Our Case Number: ABP-320089-24

An
Bord
Pleanála

Date: 15 May 2025

Re: Wind Farm Comprising of 11 Wind Turbines and Associated Infrastructure.

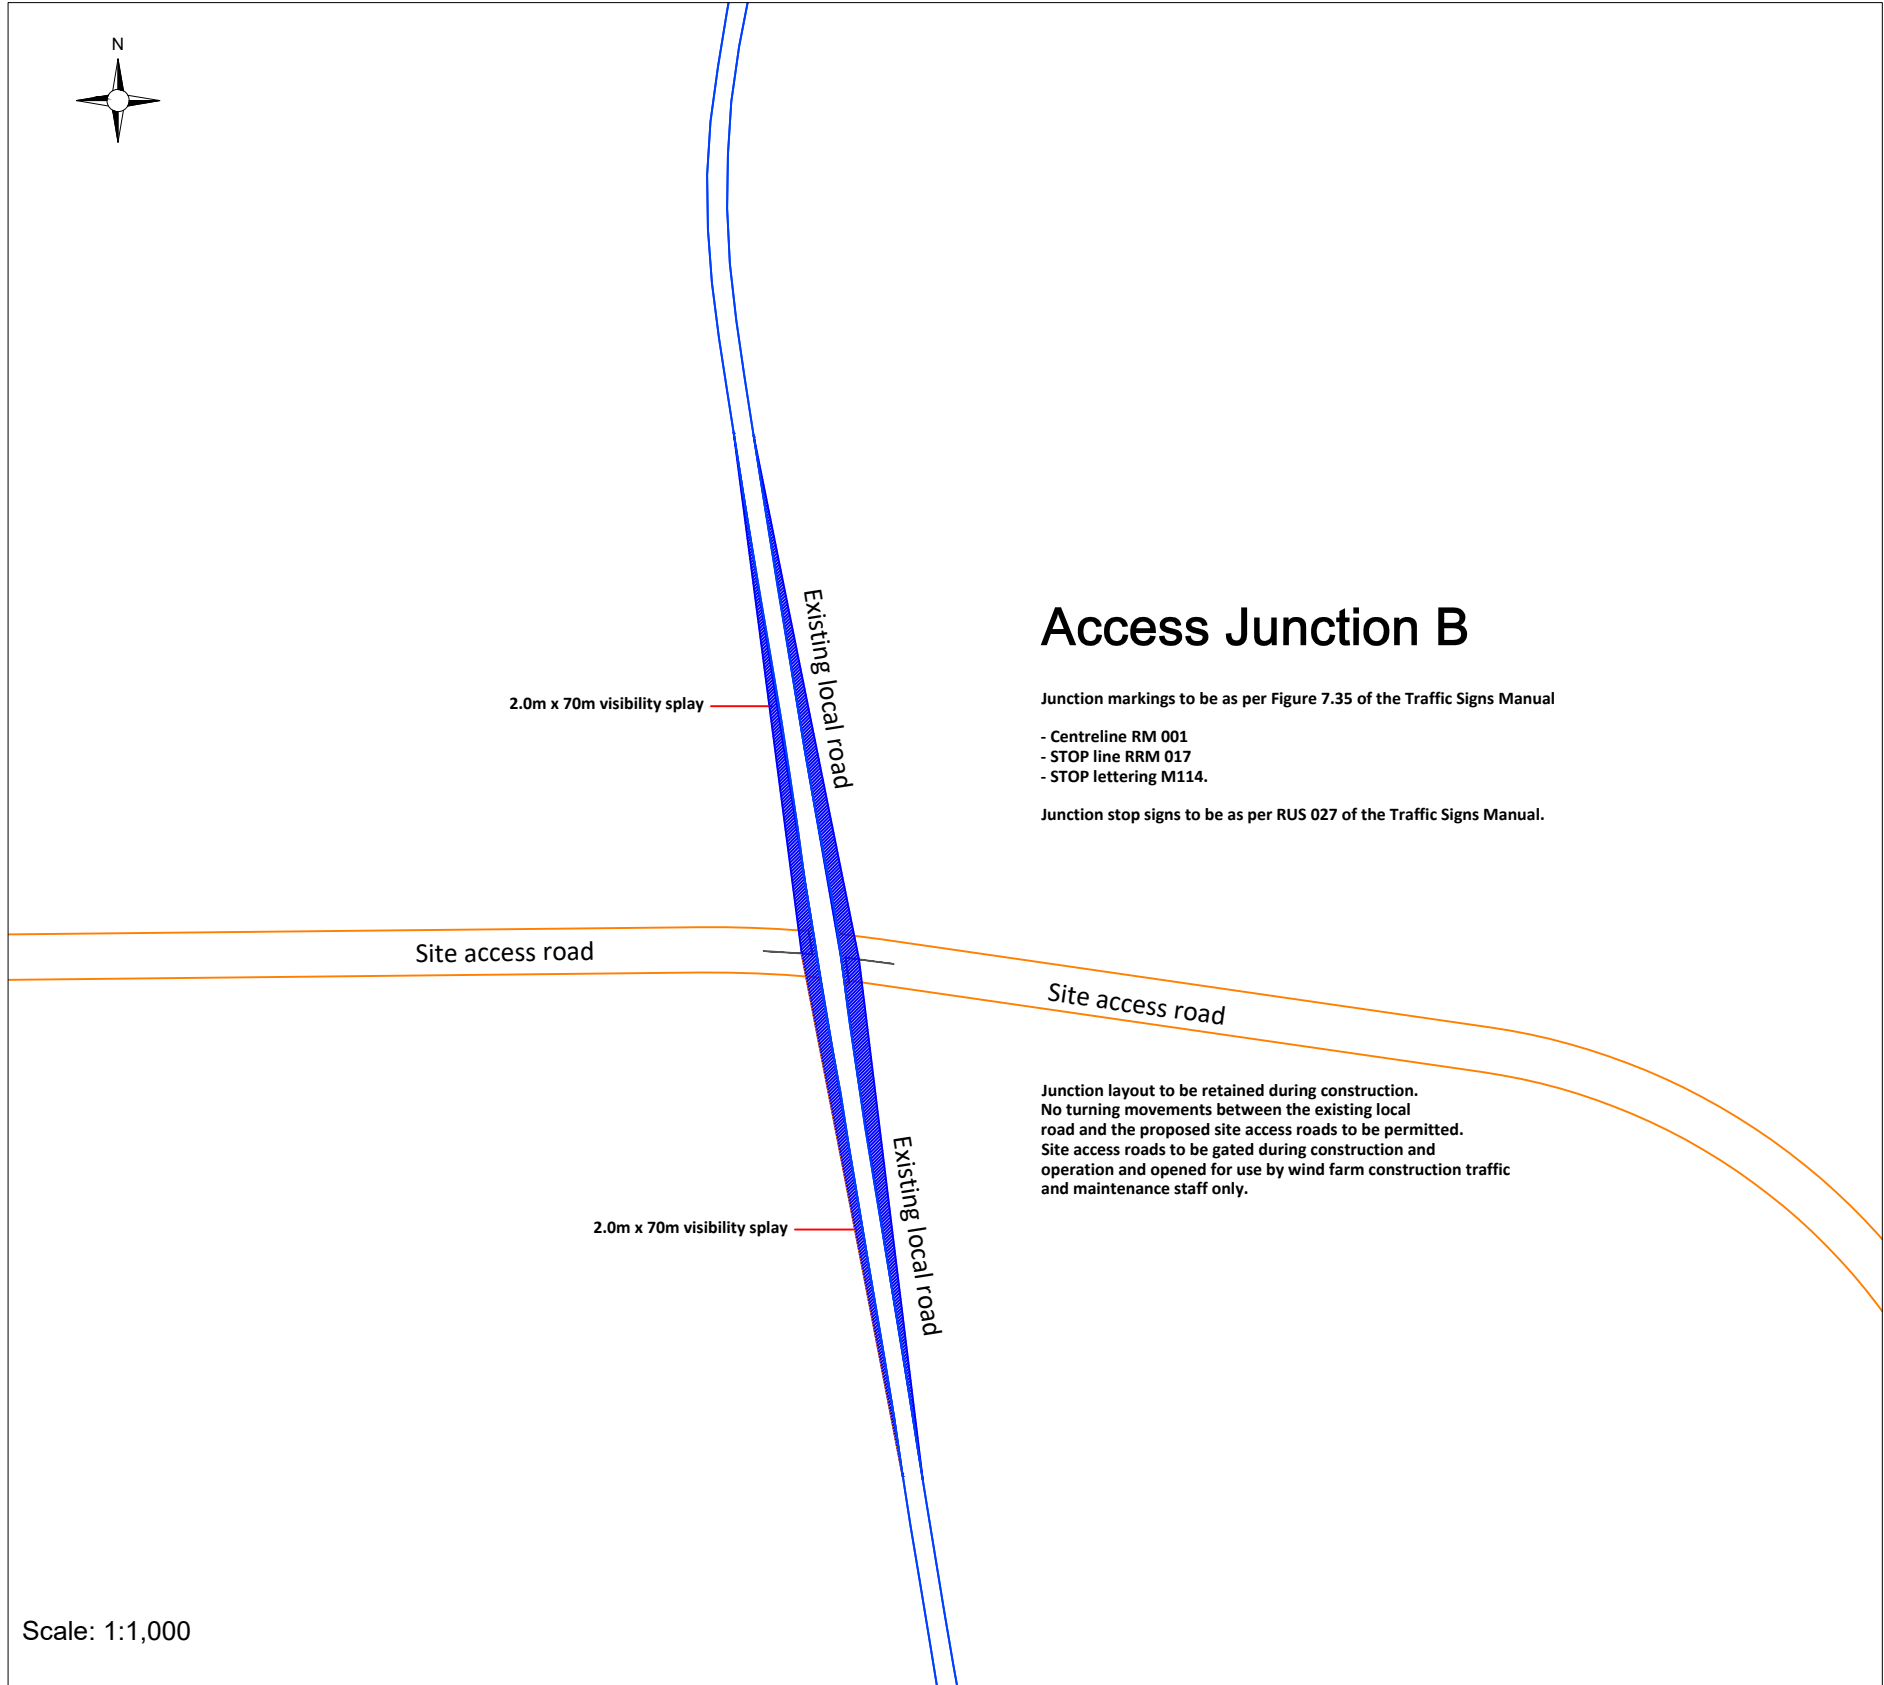
2. The proposed development in its current form fails to accord with Development Management Standard 28 of the Galway County Development Plan given the restricted eastern visibility splay from the construction entrance on the R328 (Junction A). Notwithstanding the mitigation measures proposed, you are requested to install an Automatic Traffic Counter (ATC) to determine the 85th percentile (design speed) at this location. Demonstrate the vertical envelope of visibility (i.e. intervisibility in relation to crest/sag road profile) onto the R-328 in accordance with the relevant TII standards.

3. Submit a proposed boundary treatment plan for the access with the R329 (Junction A) following the completion of the abnormal load delivery phase and following completion of the overall construction phase of the development.
